29 August 2018

**ASICS FACILITY, SYDNEY BUSINESS PARK (SSD 9153) – RESPONSE TO SUBMISSIONS –
ADDITIONAL INFORMATION**

LANDSCAPE SITE PLAN
SCALE - 1:500

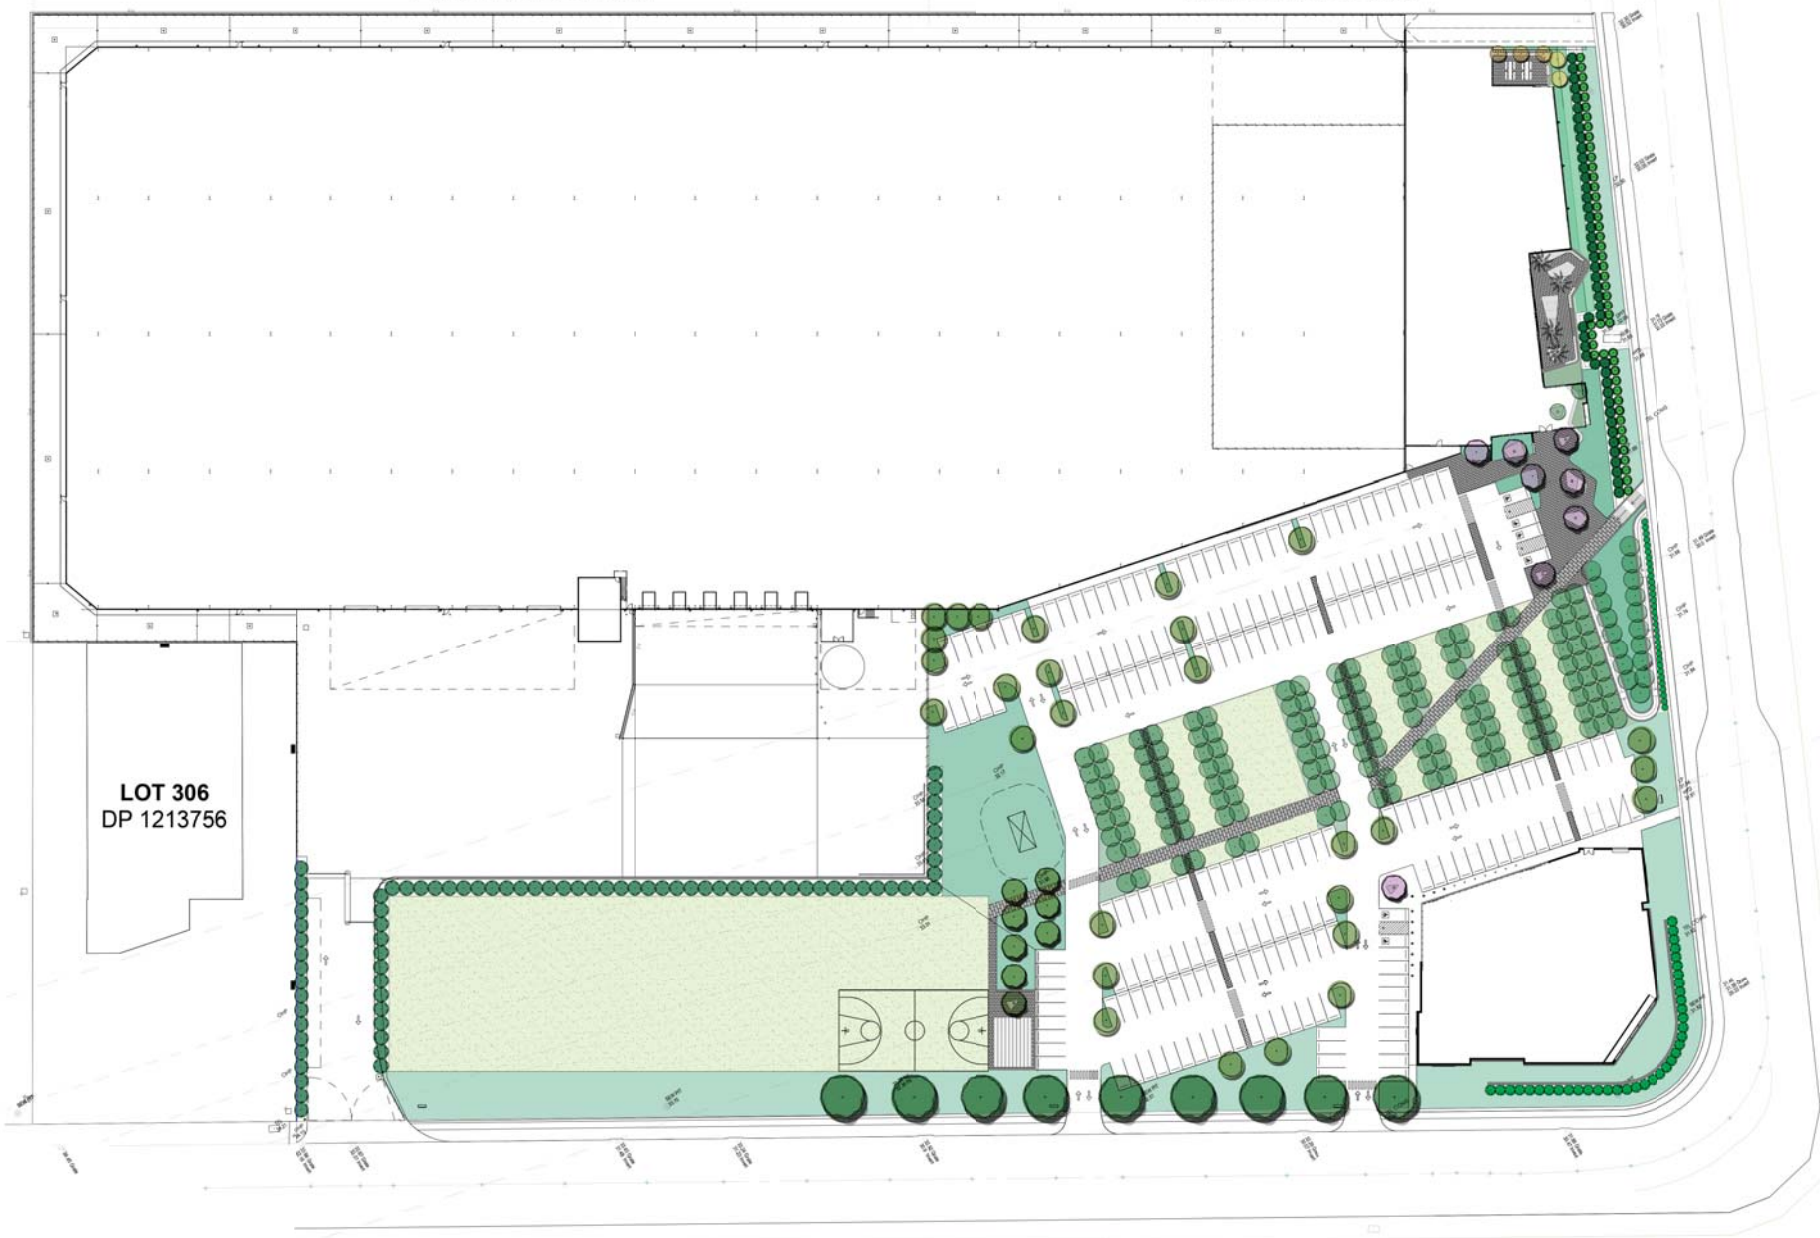
- removing all parking spaces within 17 metres of the transmission line centreline;
- removing all parking spaces within 20 metres of the transmission line structure (with the exception of some minor encroachments), and minimising thoroughfares as far as practicable;
- removing the private sports field and court from within 17 metres of the transmission line centreline; and
- ensuring suitable access is provided to Transgrid's easement and infrastructure, including:
 - removing the boom gates to the car park; and
 - removing the Armco railing around the car park adjacent to the transmission structure base.
